I am reviewing the plans submitted for 257 Brighton Avenue and have the following plan review comments:

Leader
Review/Code Enforcement
Portland, Maine
Inspections Division
Congress Street
Portland, ME 04101

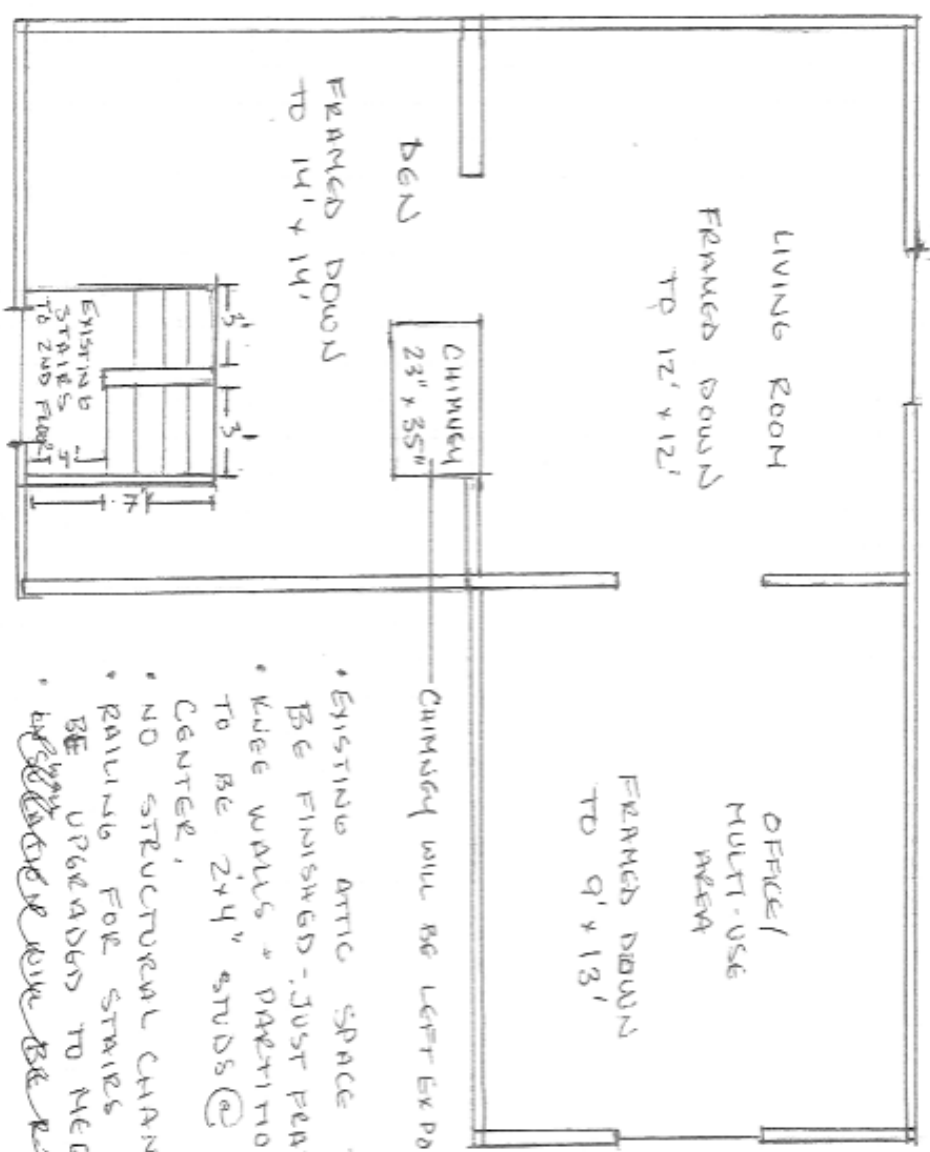
- Provide emergency escape and rescue opening per R310 for habitable attics.
- Clarify what the existing conditions are for the exterior walls and ceilings in the attic space. What is the existing insulation for the walls and ceilings? Provide R value for proposed insulation. *No Existing Insulation, wall + ceilings will be 2x6 Frame*

- Provide proposed GWB on walls and ceiling. *1/2 inch Gyp Board*
- Provide stair rise and run of existing stairs to attic space per R311.7.4. *7 3/4 x 10*

- Provide handrail height and dimensions per R311.7.7. *None Existing new railing will comply*
- Provide CO and smoke alarms per R314 and R315. *They will be installed per code*

- Clarify the ceiling height throughout the entire attic space per R305.1.

*Existing 22" off floor
R38*

Ceilings throughout will be atleast 7' and over 50 percent of floor space

Dimensions from inside of knee walls.

65% of overall floor space will be over 7'

Stairwell From Above

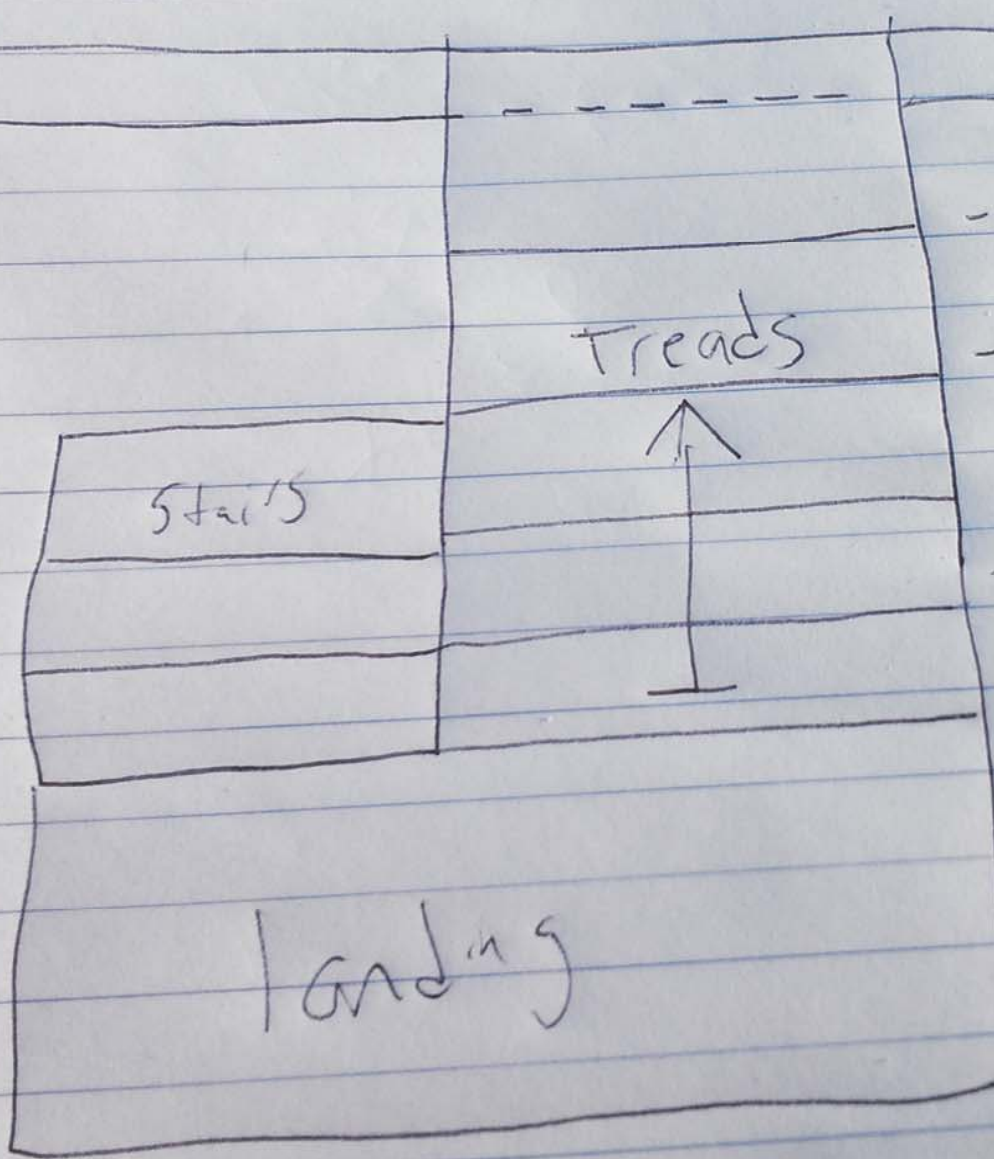
- Provide headroom of stairs to attic per R311.7.2. *71" existing, will be framed to 6'8"*
- Provide width of existing stair to attic space per R311.7. *35"*
